Re: Planning Application 19/0314

Address: Mill Cottage Victoria Terrace Mellor Brook BB2 7PL

Description: Application for the discharge of condition 4 (energy supply), 5 (proposed boundary walling, gates and fencing), 8 (provisions for building dependent species of conservation concern, artificial bird nesting boxes and artificial bat roosting sites), 9 (method statement), 12 (scheme for the construction of the site access), 14 (construction method statement), 17 (surface water drainage scheme) and 18 (sustainable drainage management and maintenance plan) from planning permission 3/2016/0092.

Drawing Title  
Proposed Overall Site Plan

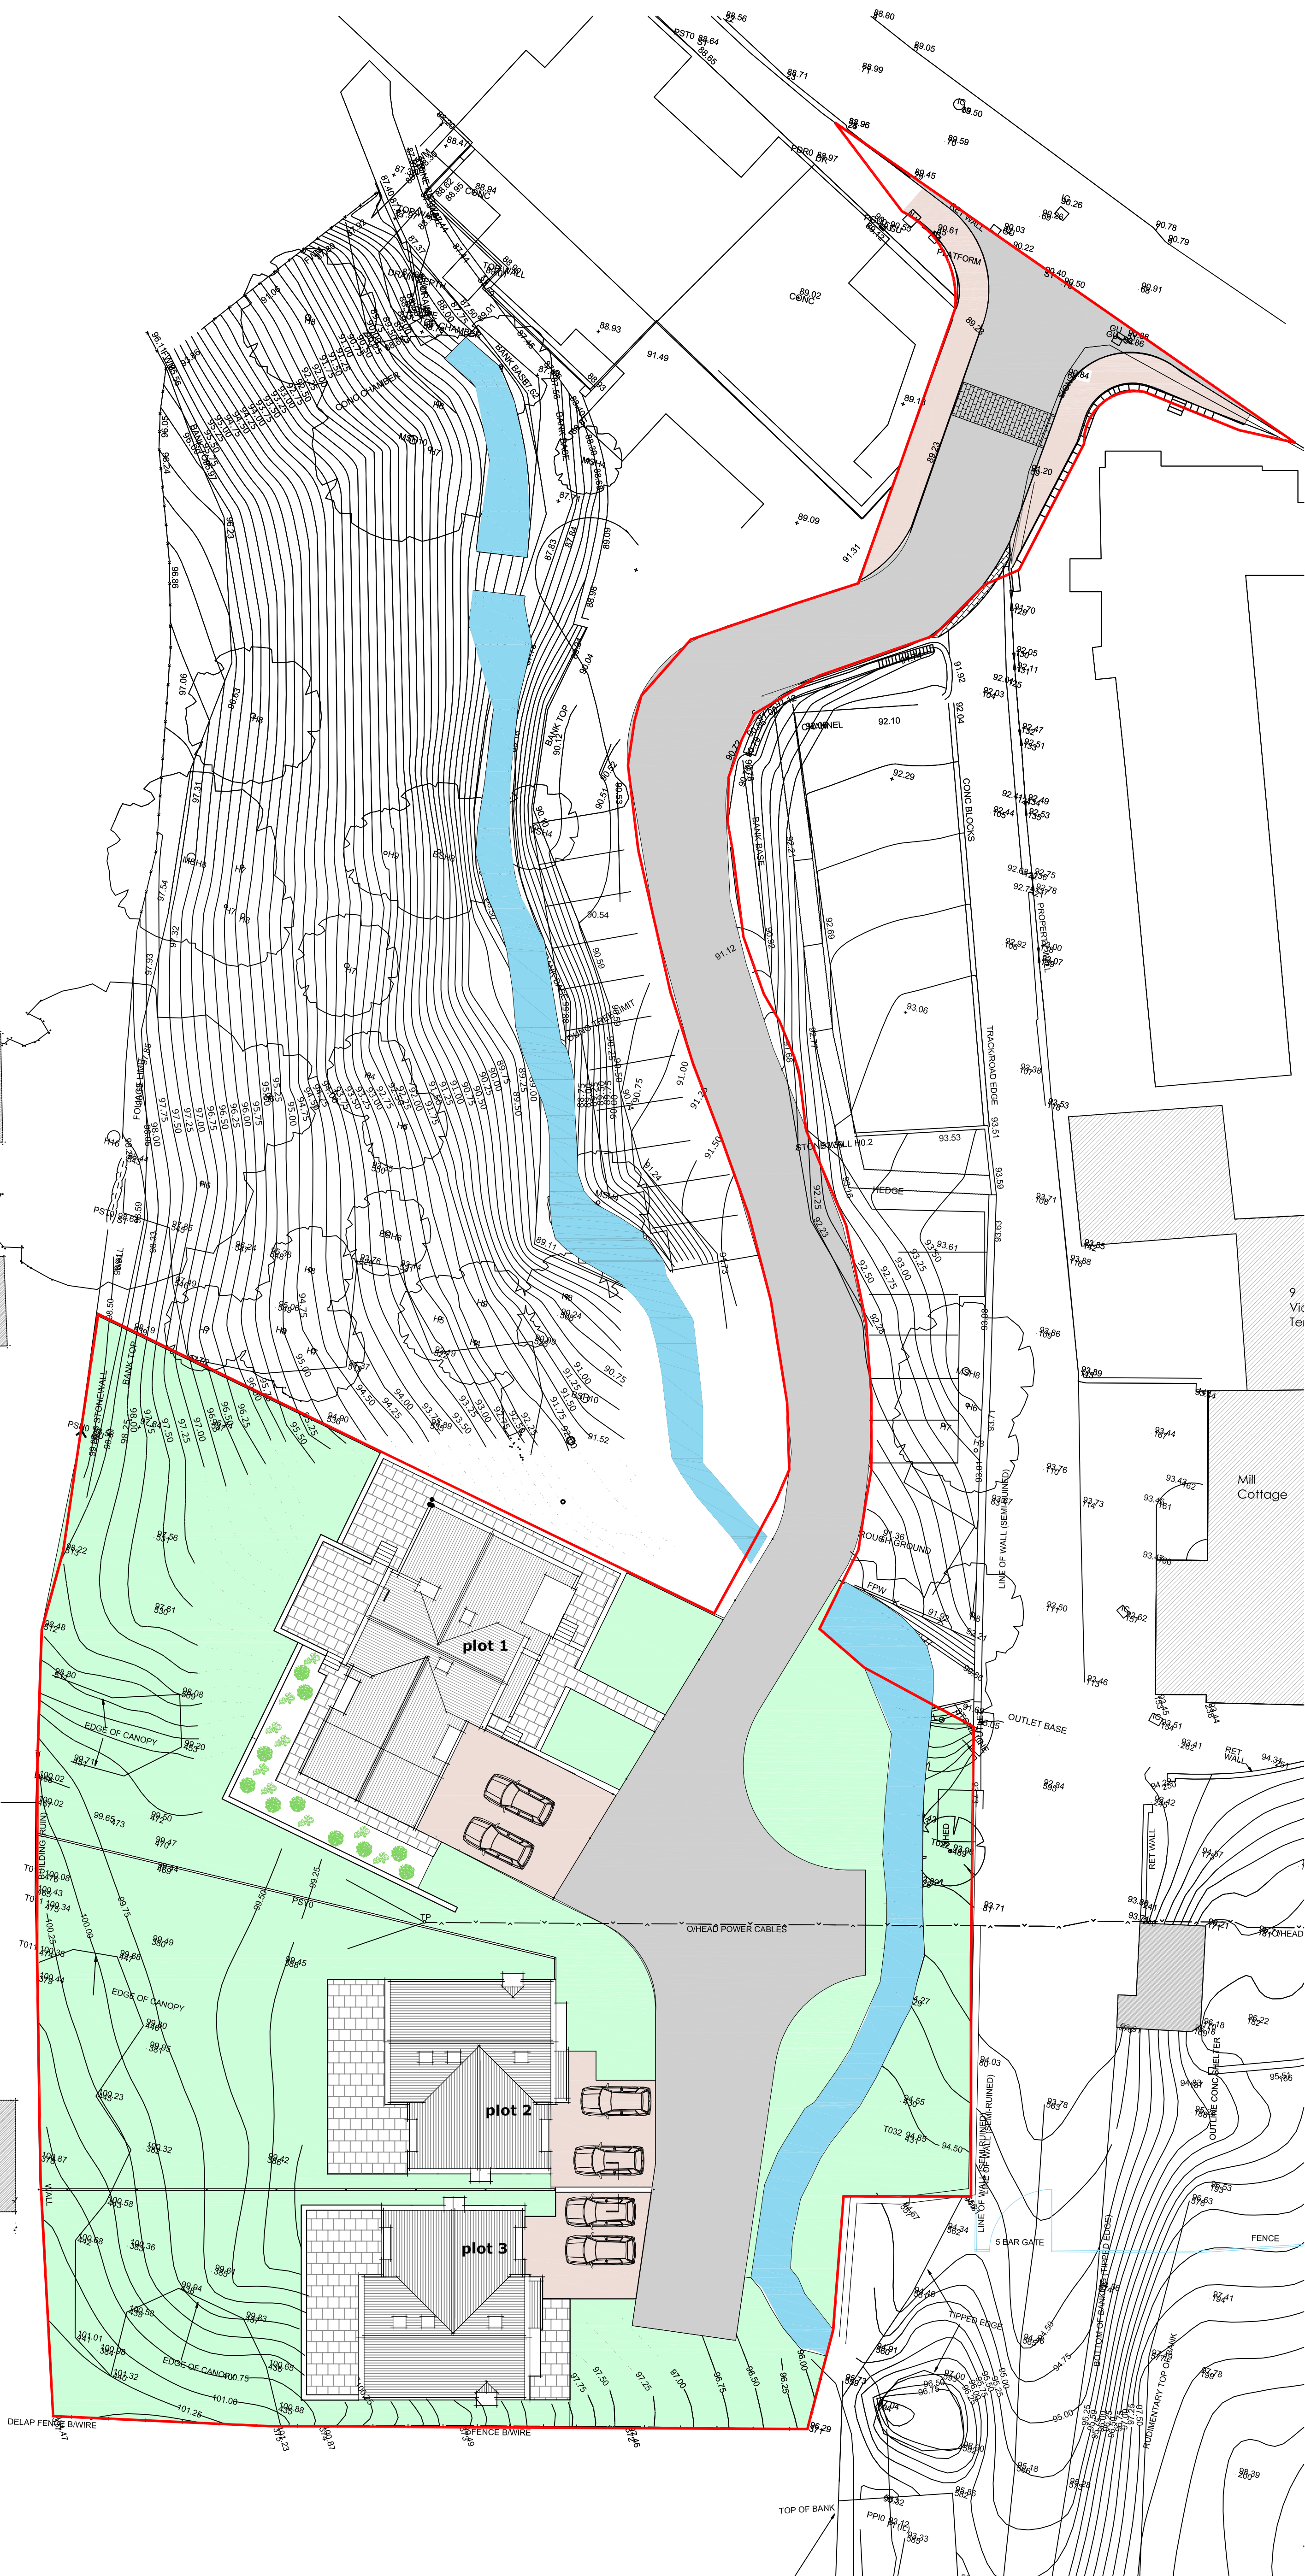
It is expected that the access should be built in line with the drawings provided, however it should be noted that there is an existing street light that will require relocations at the developers expense.
